FIRE RISK MANAGEMENT, INC

Date: 25 October, 2013

Memo Report

Subject: Code Review; ICW Proposed Munjoy Heights Development

DRAWING NO.  
**C-10**

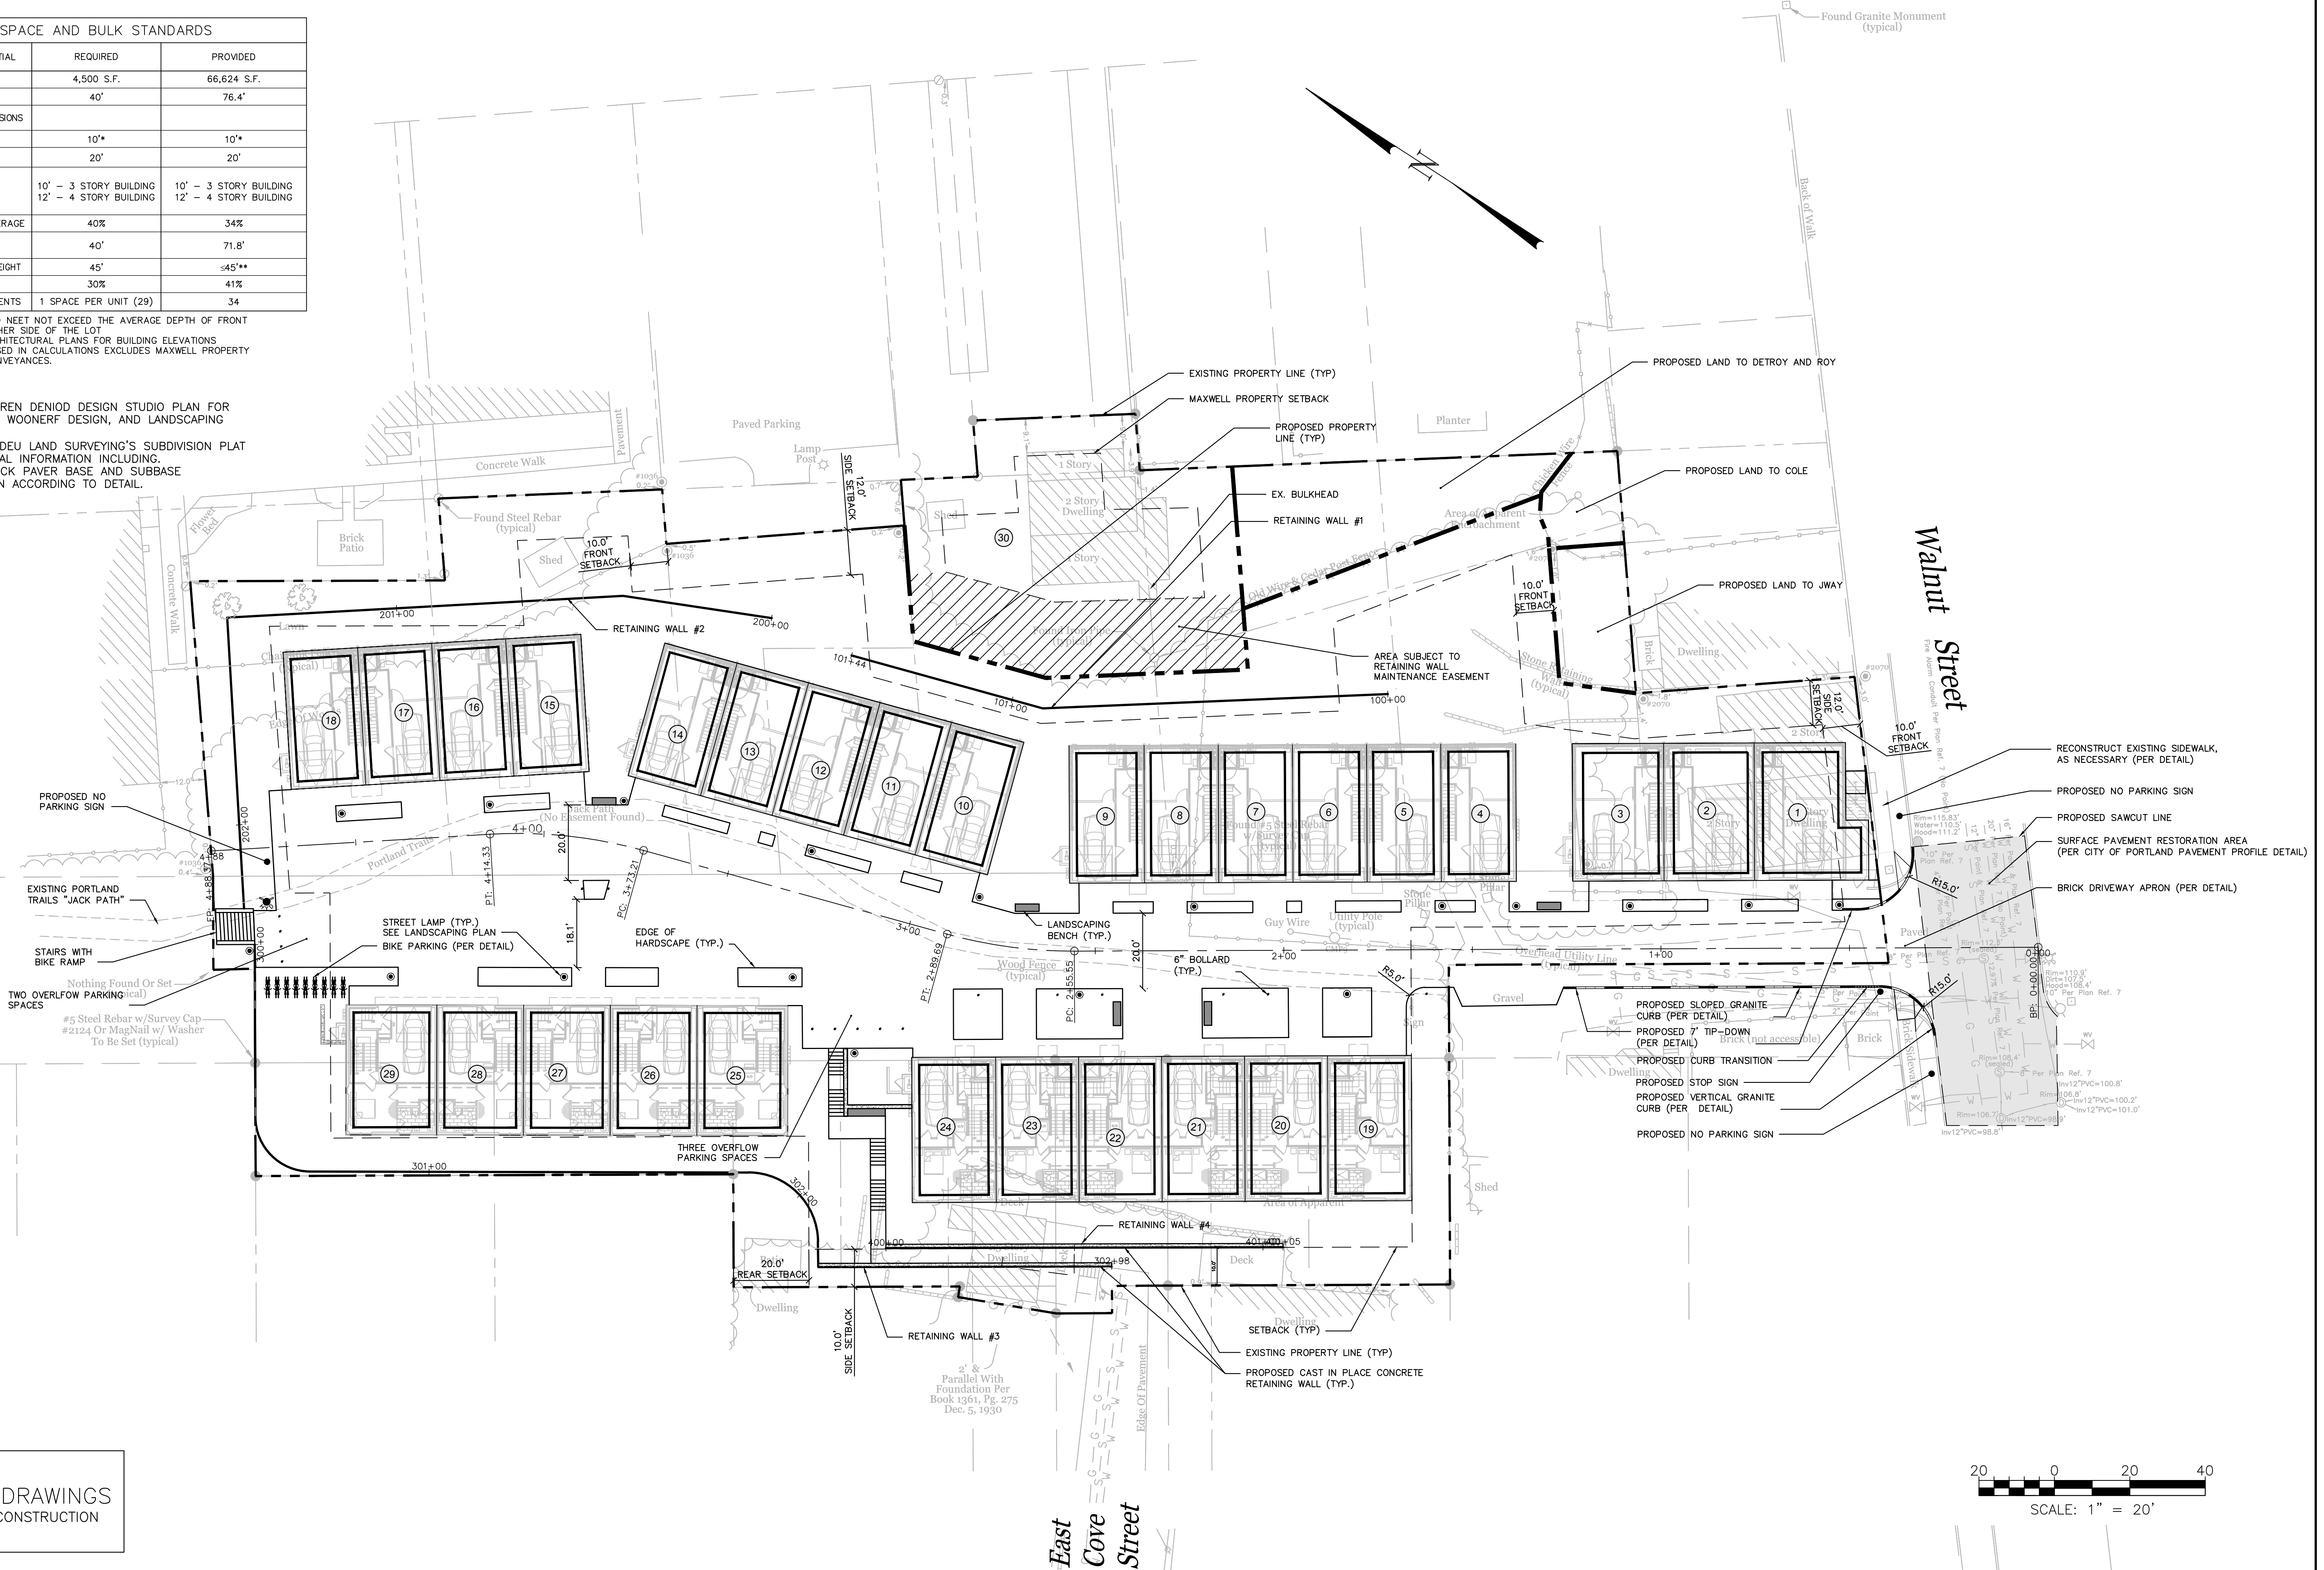
- *The access road must be at least 16 feet in width to meet City requirements.* The NFPA 1 would require this access road to have at least 20 feet in clear width. The access road shown on the site plan will provide up to 20 feet of clear width along its entire length.

- *Any dead-end access roads in excess of 150 feet must be provided with an adequate turn-around area.* The total length of the access road into this development is approximately 450 feet. As such, a turn-around area is required. As depicted on the site plan, a turn-around area is provided at the end of the access road that complies with the City's requirements for this feature. Specifically,

- *NFPA 1 requires that at least one (1) fire hydrant be within 250 feet of this site. The City also has a requirement that a hydrant must be within 100 feet of any Fire Department Connection (FDC).* Given the water flow requirements needed to support firefighting operations, which is based on the building size and construction type, a fire hydrant must be within 250 feet of any part of the frontage on access road. A new, private fire hydrant is to be located at the end of the access road and a hydrant exists at the intersection of the access road and Walnut St. These hydrant locations ensure that all frontage on the development's access road will be within the 250-foot limit. However, the distance from the hydrants to the likely locations of some of the buildings' FDCs will be outside the 100-foot limit outlined by the City's Rules and Regulations. In recent discussions with a representative of the City's Fire Prevention Bureau, whereby the validity and benefit of this specific requirement has been questioned, it was stated that this regulation may be waived and only those requirements outlined in NFPA 1 must be adhered to for this particular project.

- *Based on the construction type and size of the largest individual building within the development, NFPA 1 would require a minimum fire flow (fire water supply capabilities) of at least 1000 gpm.* Using the building parameters that resulted in the largest fire area (Building B), coupled with a Type V (000) construction type as defined by NFPA, the initial fire flow requirements would be approximately 3500 gpm. However, this value can be reduced by 75% when the building is protected by an automatic fire sprinkler system, down to a minimum of 1000 gpm. This value could be reduced further if quick response sprinklers are used, which is likely for residential buildings, but this was not taken into account for this review. The fire hydrant that is located in the vicinity of the intersection of Walnut St. and the access road (corner of Walnut and Sheridan Streets) has a "light blue" color painted on the bonnet. This indicates that this hydrant can support fire flows in excess of 1500 gpm (at a minimum of 20 psig residual pressure at the hydrant). It will be assumed that the new private fire main system will tie into the City's fire main system in a near vicinity to this hydrant and, thus, the new private hydrant will also have water flow capabilities similar to that of the City's hydrant. As
